Response to Planning application from Hertfordshire County Council (T and CP GDP Order 2015)

District ref: 21/00014/FP
HCC ref: SV/5246/2021
HCC received: 13 January 2021
Area manager: Matthew Armstrong
Case officer: Paul Marshall

14 PENN ROAD STEVENAGE SG1 1HY

Conversion of existing 4 bed dwelling into 2no. 2 bed flats

PROPOSED SITE PLAN SCALE 1:200
SITE AREA = 331.6m²

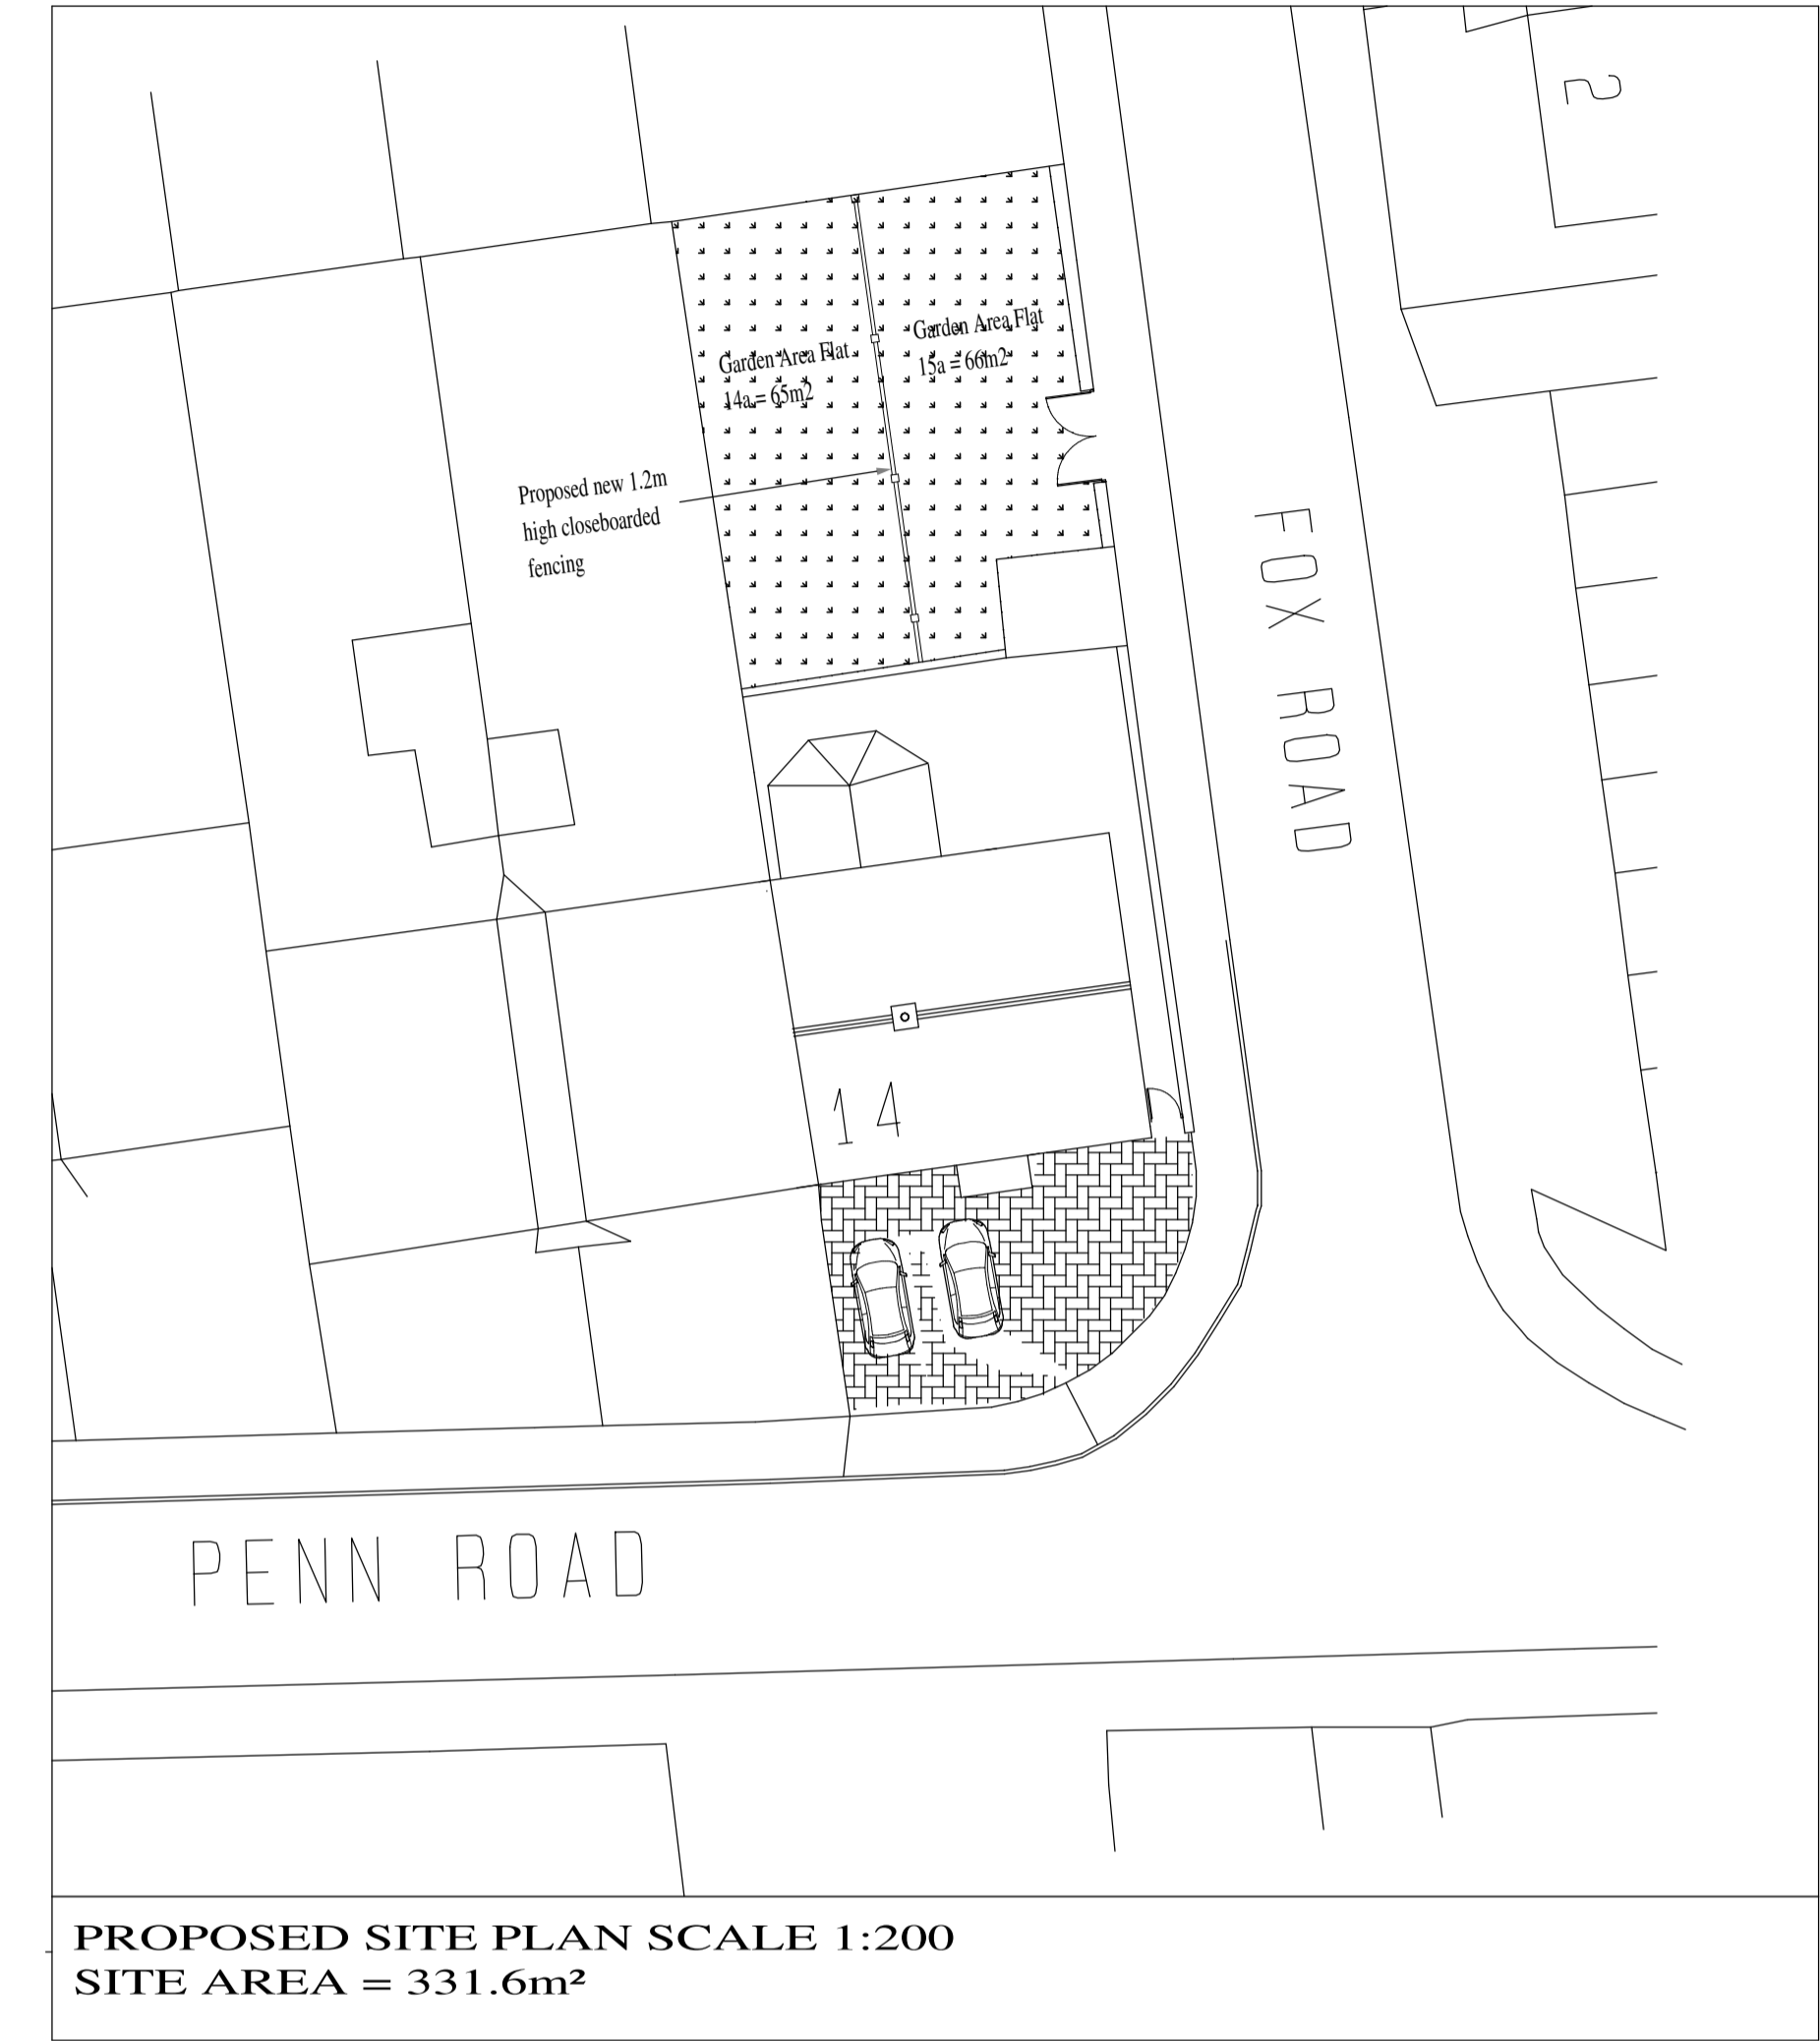
The proposal is for 4 parking spaces, SBC residential parking standards recommend 1.5 spaces per 2-bedroom dwelling. It is down to the parking authority to determine if this is acceptable. The parking area is approx. 9.5 x 6.5m which if 4 vehicles were parked at one time, occupants of both flats would likely need to agree how vehicles are parked e.g. if 4 vehicles were parked how does the 4th vehicle nearest Fox Road manoeuvre out. It is my opinion that this is not workable, and that parking area is inadequate for safely parking of 4 vehicles.

'Cycle Infrastructure Design' DfT Local Transport Note 1/20 (July 2020) recommends there should be parking for 2 cycles per dwelling (1 is acceptable). Outside cycle parking should be covered and lockable. This is not currently demonstrated in the proposals and furthermore, is contrary to LTP4 which states: Hertfordshire County Councils Local Transport Plan (LTP) 4 policy 5, is to "ensure the location and design of proposals reflect the LTP Transport User Hierarchy and encourage movement by sustainable transport modes".

Due to the lack of demonstrated cycle parking and inadequate space to realistically park 4 vehicles the Highway Authority is unable to extend the grant of planning permission at this time.
